RFI #: 68  
Date: 2/29/2012  
Job: EB-02 Keller Springs Lofts  
Phone: 877-777-5115

Subject: Purposed change to the elevator detail on 9/S3.01

RFI #: 108  
Date: 4/11/2012  
Job: EB-02 Keller Springs Lofts  
Phone: 877-777-5115

RFI #: 82  
Date: 3/21/2012  
Job: EB-02 Keller Springs Lofts  
Phone: 877-777-5115

8 TYPICAL RE-ENTRANT SLAB CORNER REINFORCING DETAIL
S3.08 NO SCALE

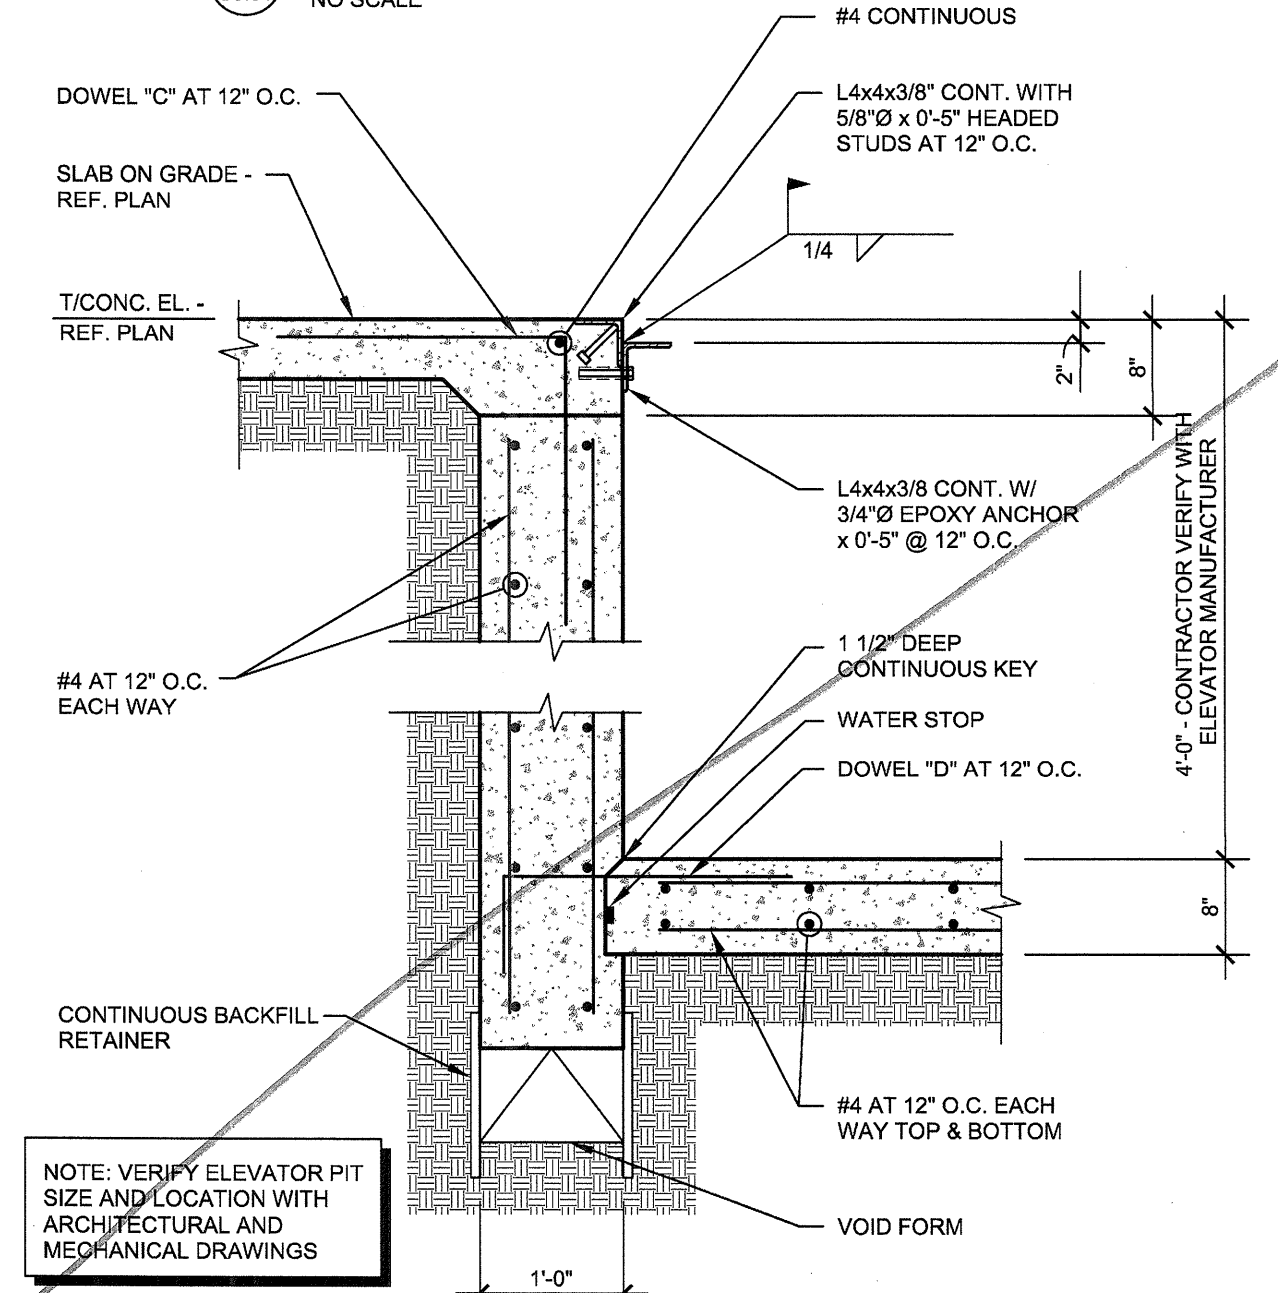
**Request:** Date Required: 3/7/2012  
We would like to purpose a change to the elevator detail on 9/S3.01. Can we pour the bottom 1st similar to the original detail on the construction issue plans (10-17-2011). The enclosed attachments have 9/S3.01 marked \*1. We have our proposed change marked \*2. Can you give us a detail the forms and pours like our \*2 detail.

Please see attached.  
R. Trent Perkins, PE  
Parkin-Perkins-Olsen Consulting Engineering, Inc.  
March 1, 2012

**Request:** Date Required: 3/22/2012  
In our meeting on 3/16/12 at your office we discussed the already poured piers on slab pour #1 as having 4-#6x5'-0" dowels as shown on 1/S3.01 vs the proper detail as shown on 3/S3.02, which requires 6 #7 dowels. You were going to check to see if we can reduce the required number of #7 dowels to go along with the in place #6 dowels.

Please provide 4 - 7 "L" dowels in addition to the 4-#6 dowels currently in place.  
R. Trent Perkins, PE  
Parkin-Perkins-Olsen Consulting Engineering, Inc.  
March 22, 2012

**S3.01**

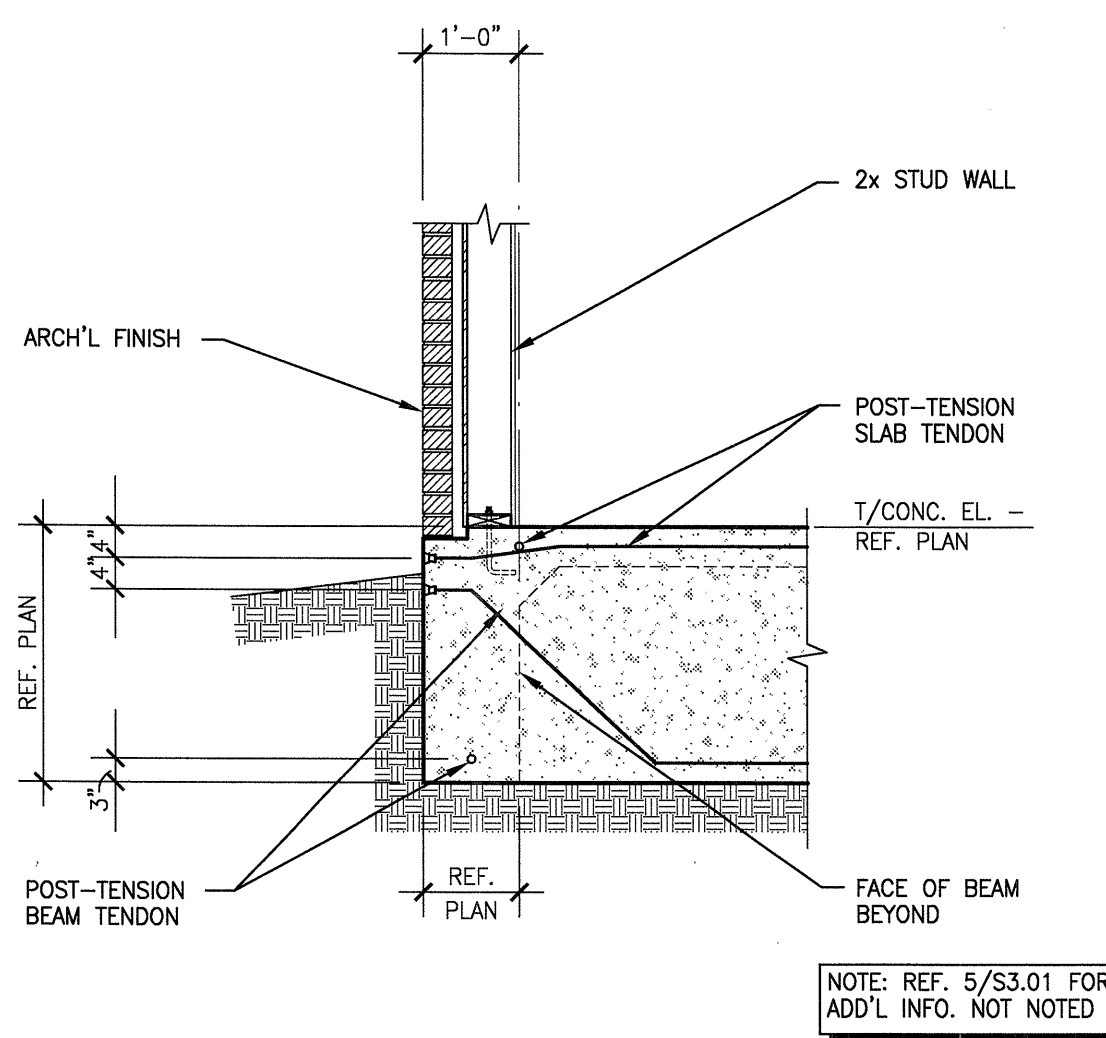
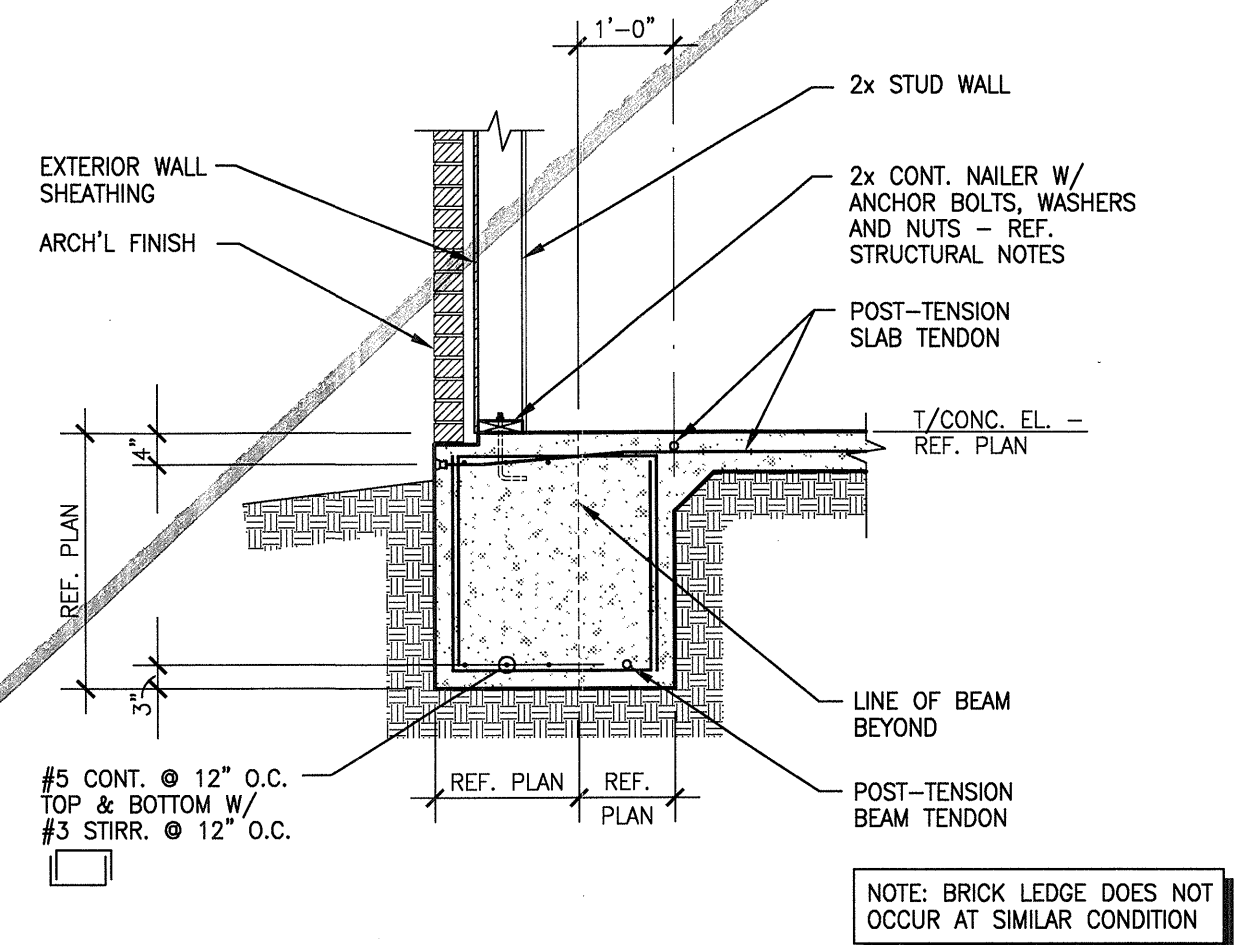
**Request:** Date Required: 4/12/2012  
There are several places on these sheets (there may be other sheets where this occurs) where a gradebeam changes elevation due to changes in top of pier elevation. On 2.11P, there are two entries into the building on the left side - one from the courtyard and one from the outside. The courtyard shows P6 piers that change to a P6A pier. Please provide details for this condition. A different condition would be on S2.13P where the interior piers (between Pours 3 and 5) are a P5 and the exterior pier is a P9. Please provide a detail showing how the grade beams come together.

Refer to details 6/S3.01 and 7/S3.01.  
If you need additional clarification, please do not hesitate to call.  
R. Trent Perkins, P.E.  
Parkin-Perkins-Olsen Consulting Engineering, Inc.  
April 11, 2012
